Phone: 07847 200073
Email: Lancashire.Archaeology@Gmail.Com
Your ref: 3/2017/0012
Date: 7th February 2017

**Planning Application 3/2017/0012: Higher Boyce Farm, Stoneygate Lane,
Ribchester PR3 3YN; Conversion of agricultural building into two dwellings.
Resubmission of planning application 3/2016/0177**

Proposed Ground Floor Plan
Scale 1:100

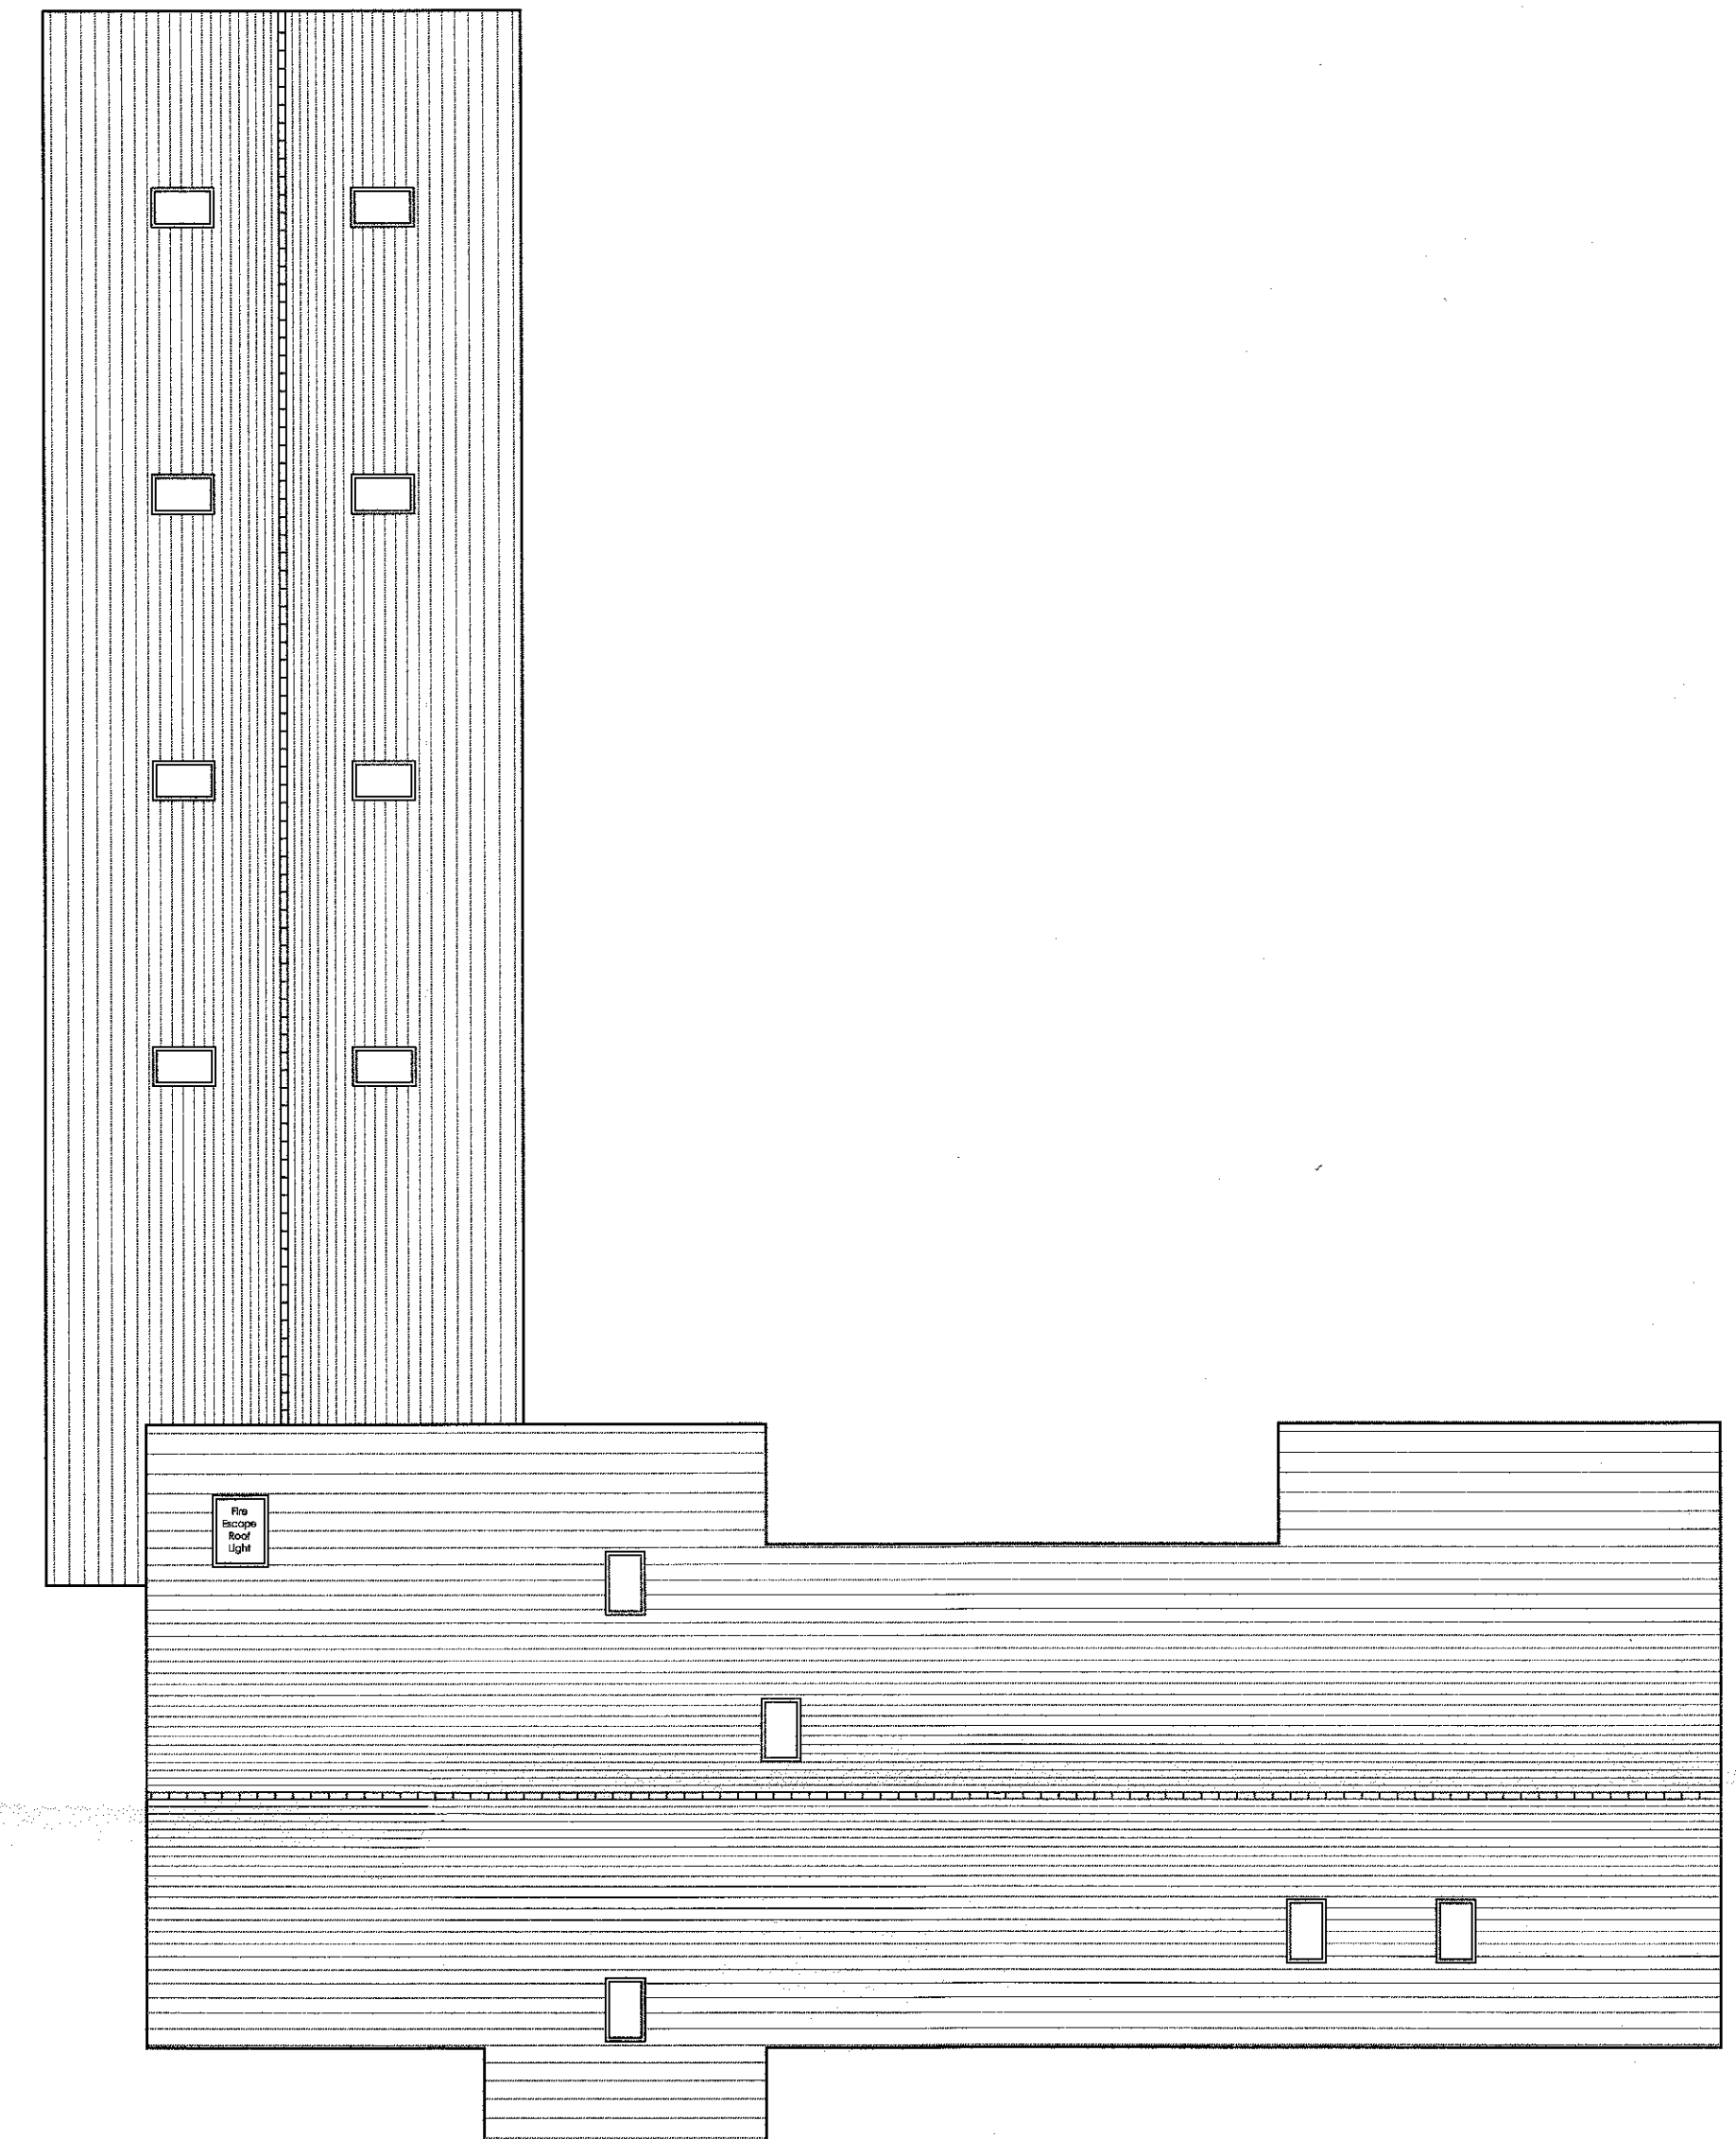
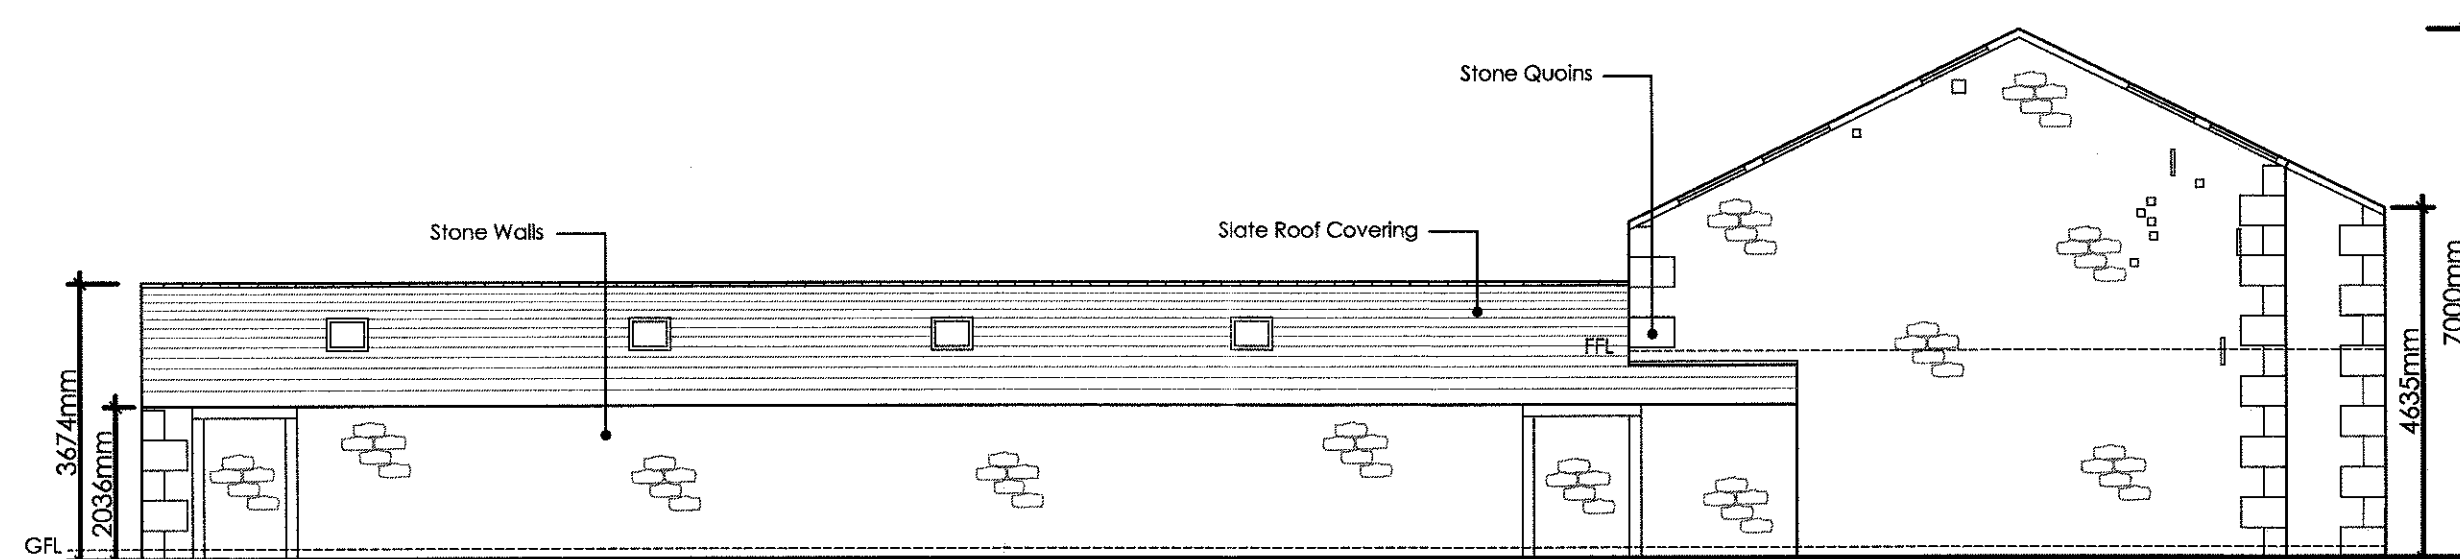
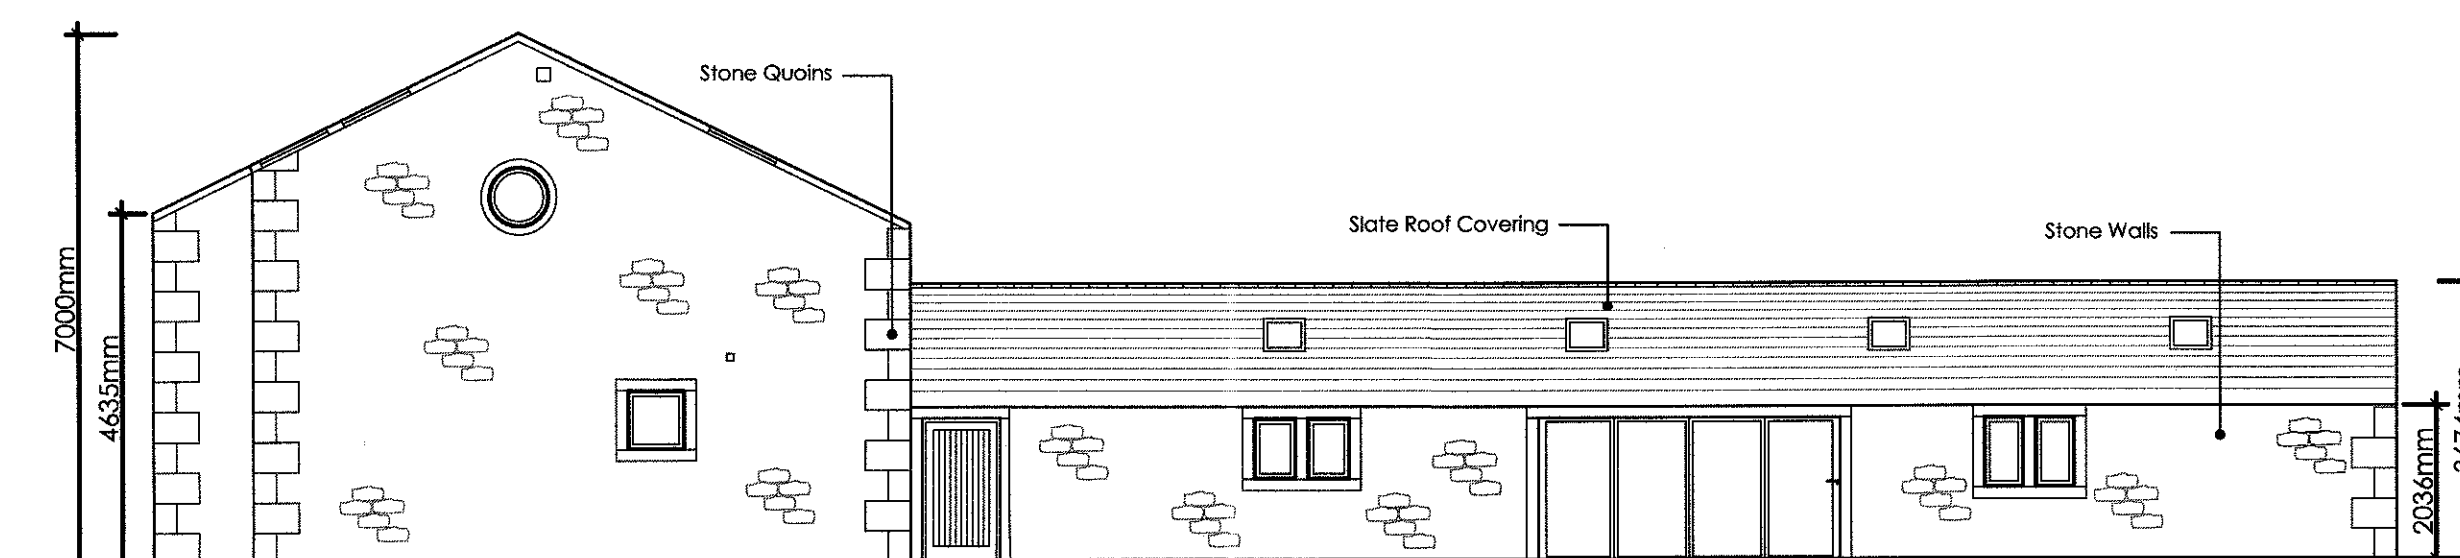
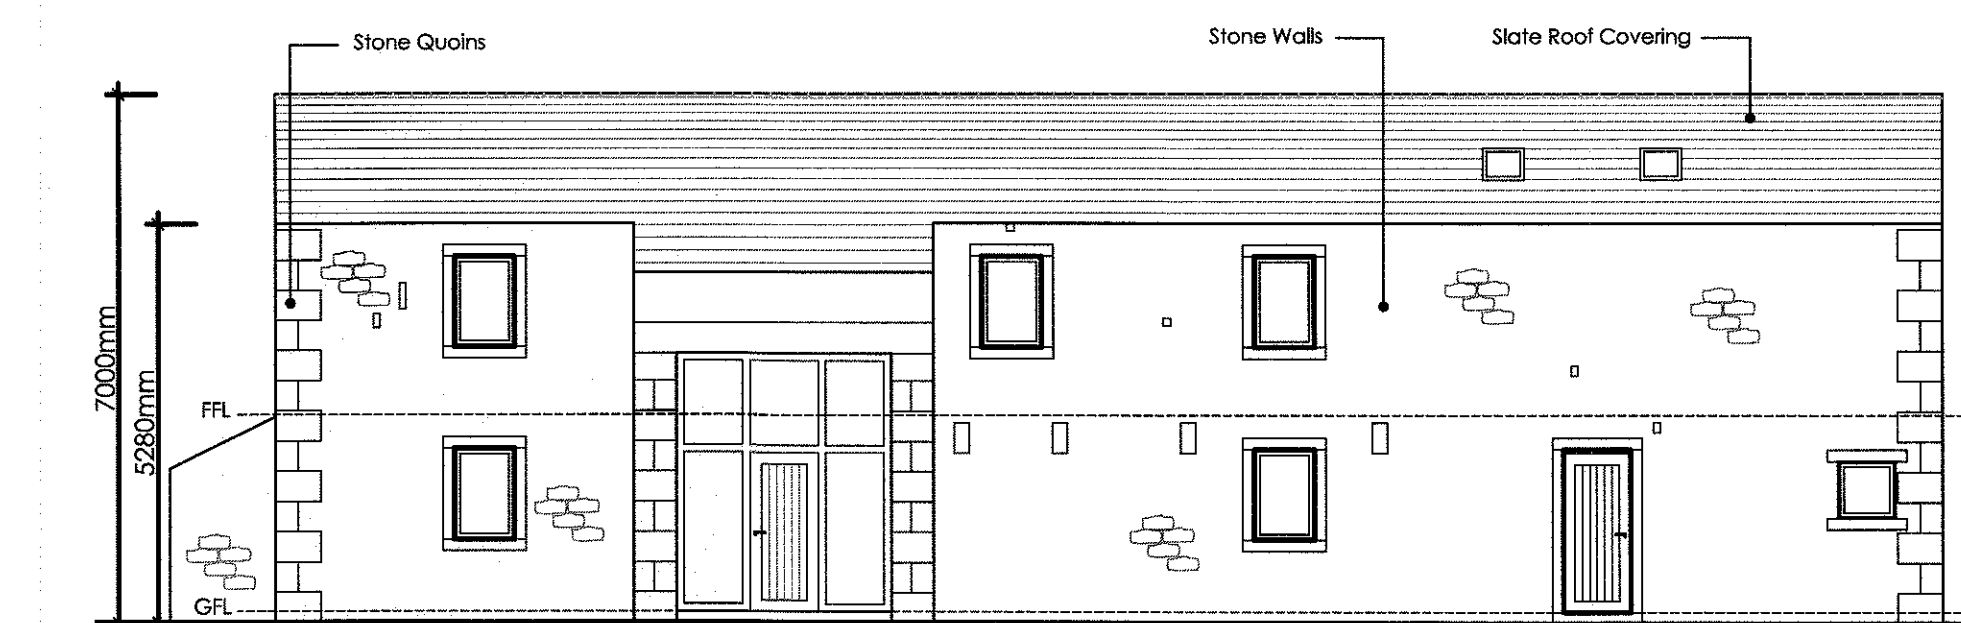
The building proposed for conversion appears on the OS 1:10,560 mapping of 1847 (sheet Lancashire 54, surveyed 1844) and had been extended by 1893 (OS 1:2,500 sheet Lancashire 54.10, surveyed 1892). As such it is considered of some heritage significance as it will retain information relating to earlier farming practices and uses. We would note that there appear to be a large number of new openings proposed in the historic fabric as part of the development and would suggest that consideration be given to reducing these in number and/or size, so as to reduce the impact on the significance of the building.
